CK Engineering LLC

Re: City of Mercer Island building official comments review for Helix Homes
residence located at 6922 SE 33rd St., Mercer Island, WA 98040

CK Engineering LLC Ref. # 22-021

SHEET NO.
A10

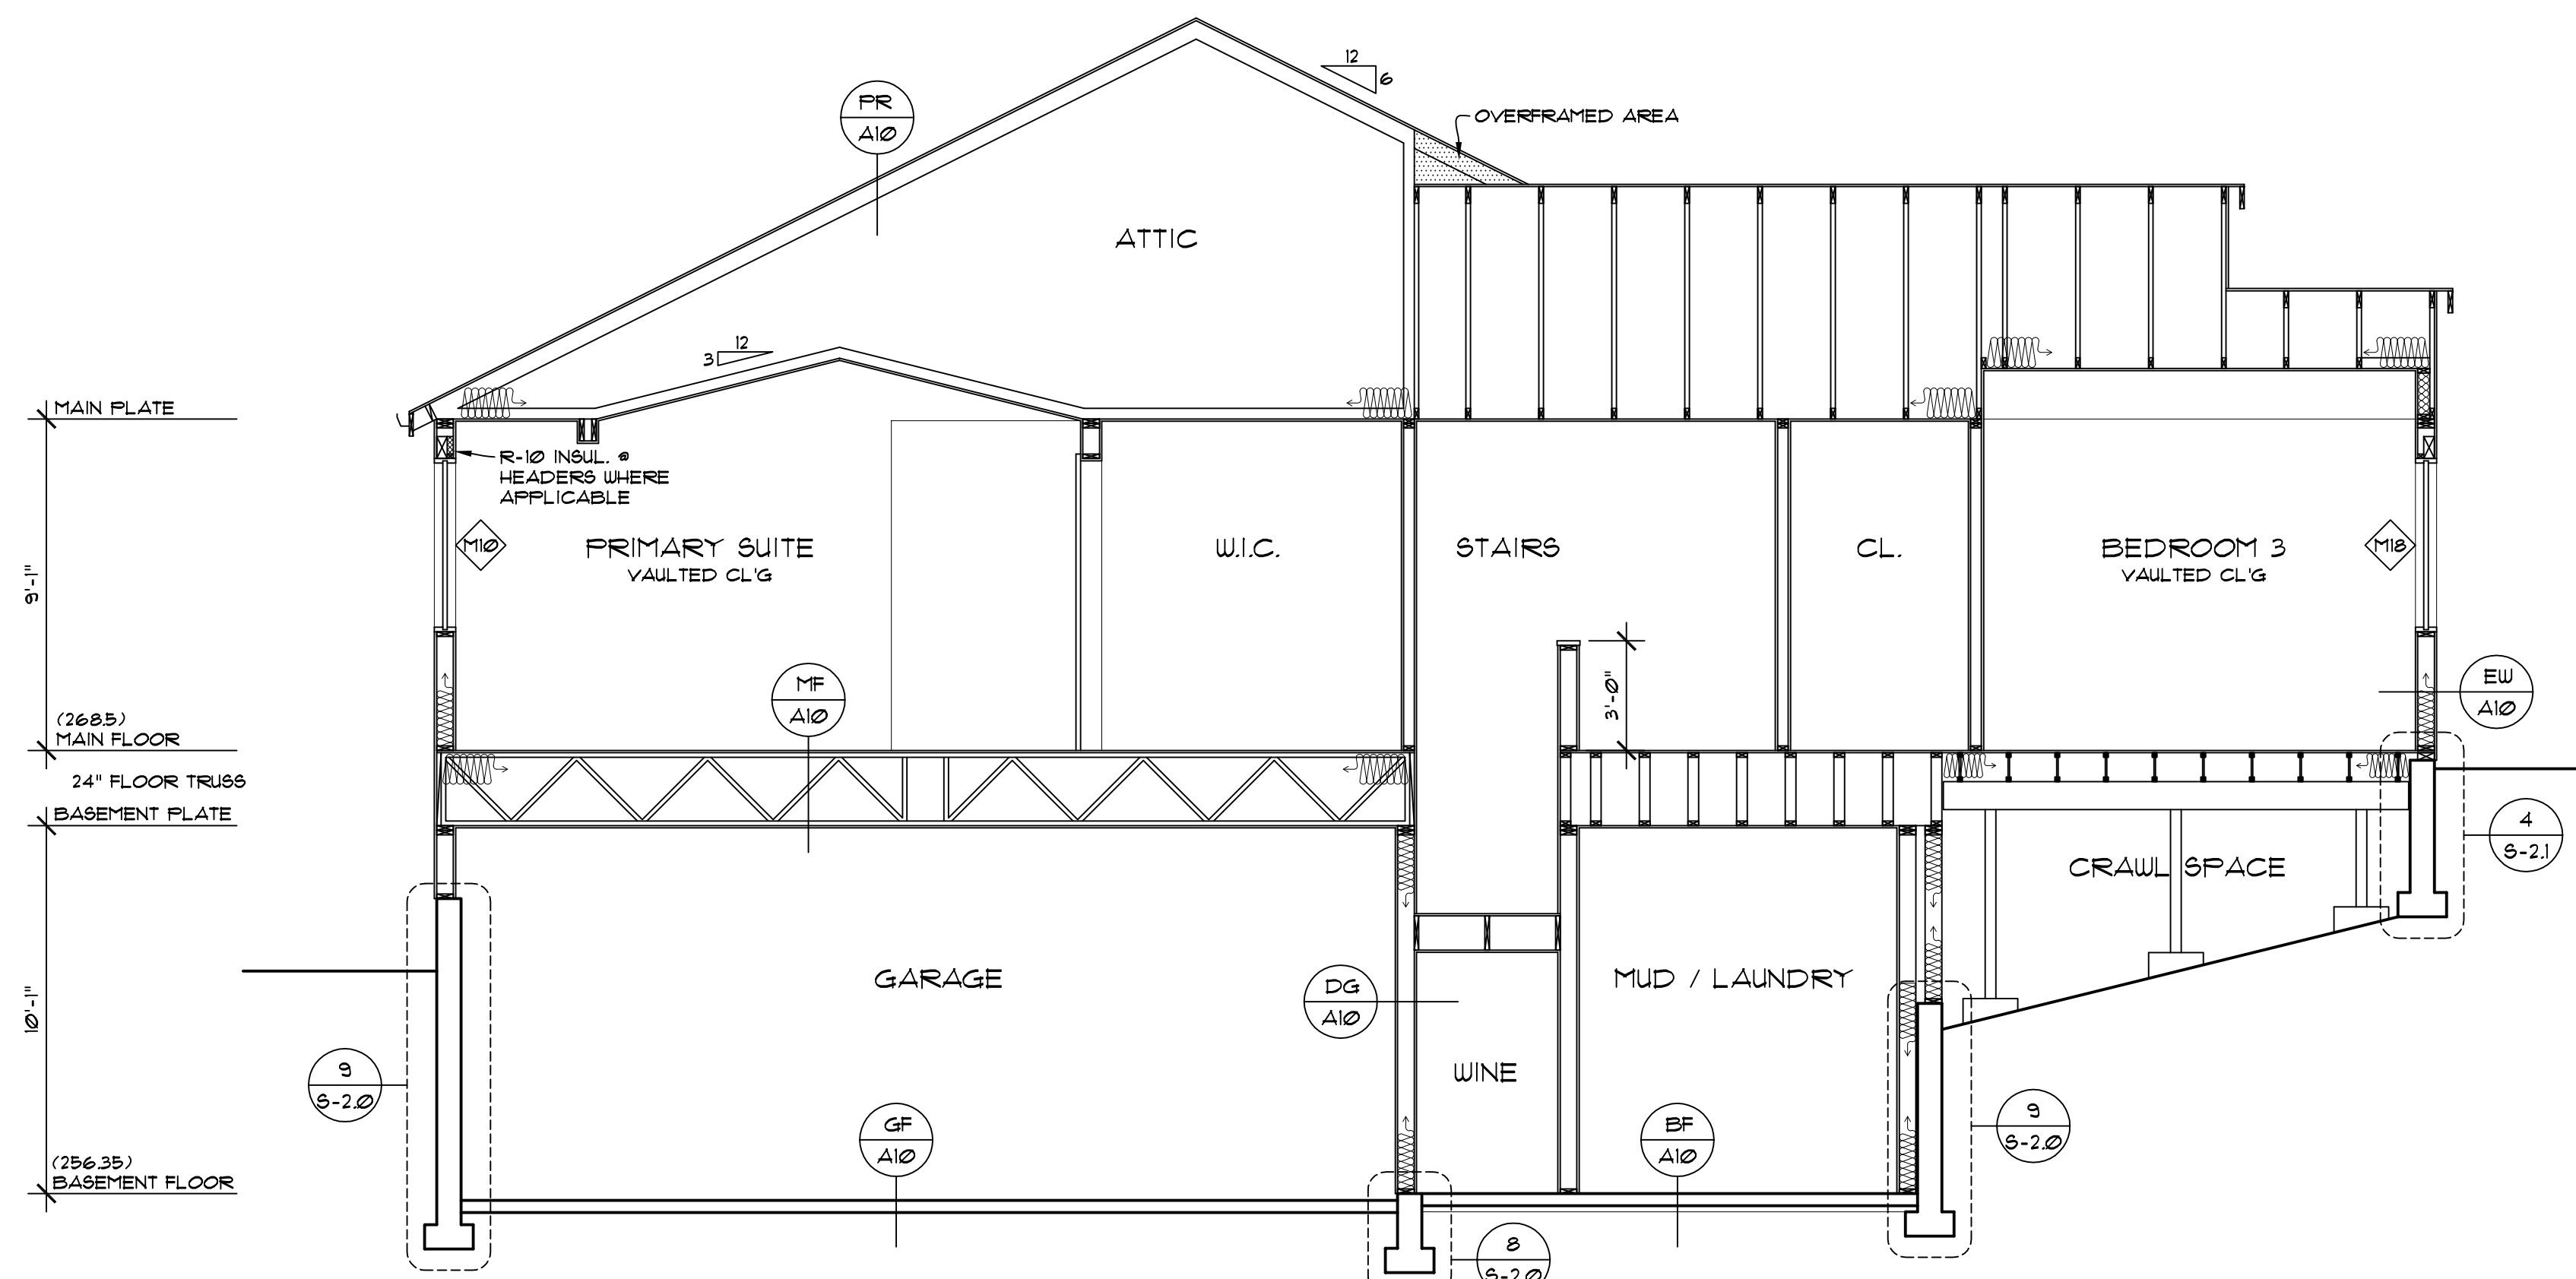
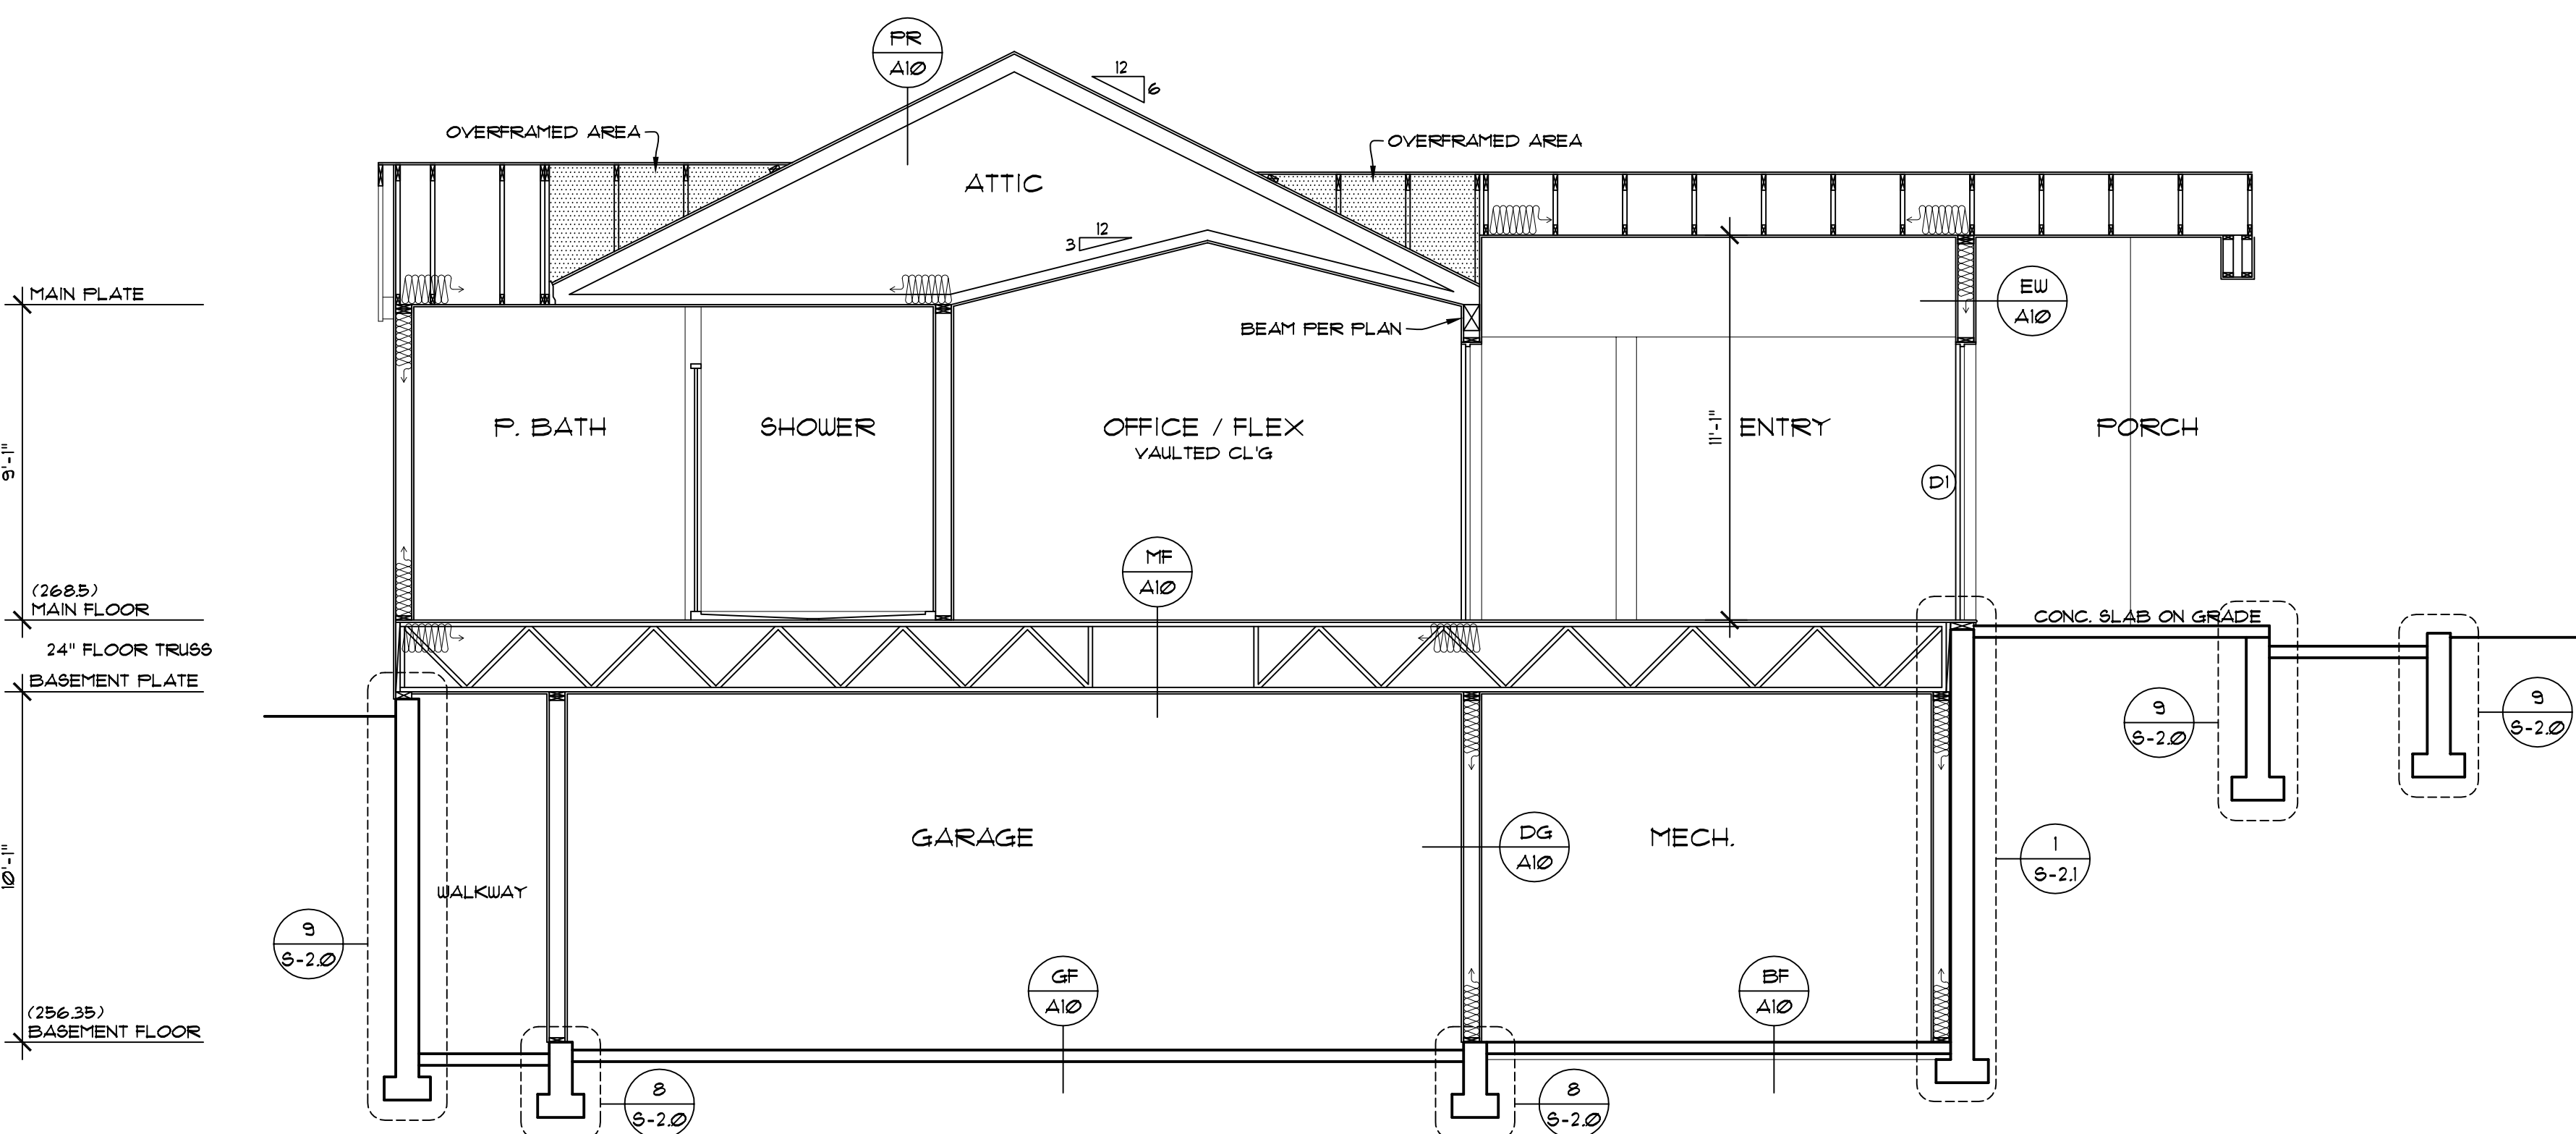
CK Engineering LLC reviewed the City of Mercer Island plan review comments regarding additional perimeter foundation surcharge as well as the sloped soil surcharge within the crawlspace on designed retaining walls.

We have reviewed revised building sections on A10, and it is our opinion that our originally proposed retaining wall design is adequate for current conditions.
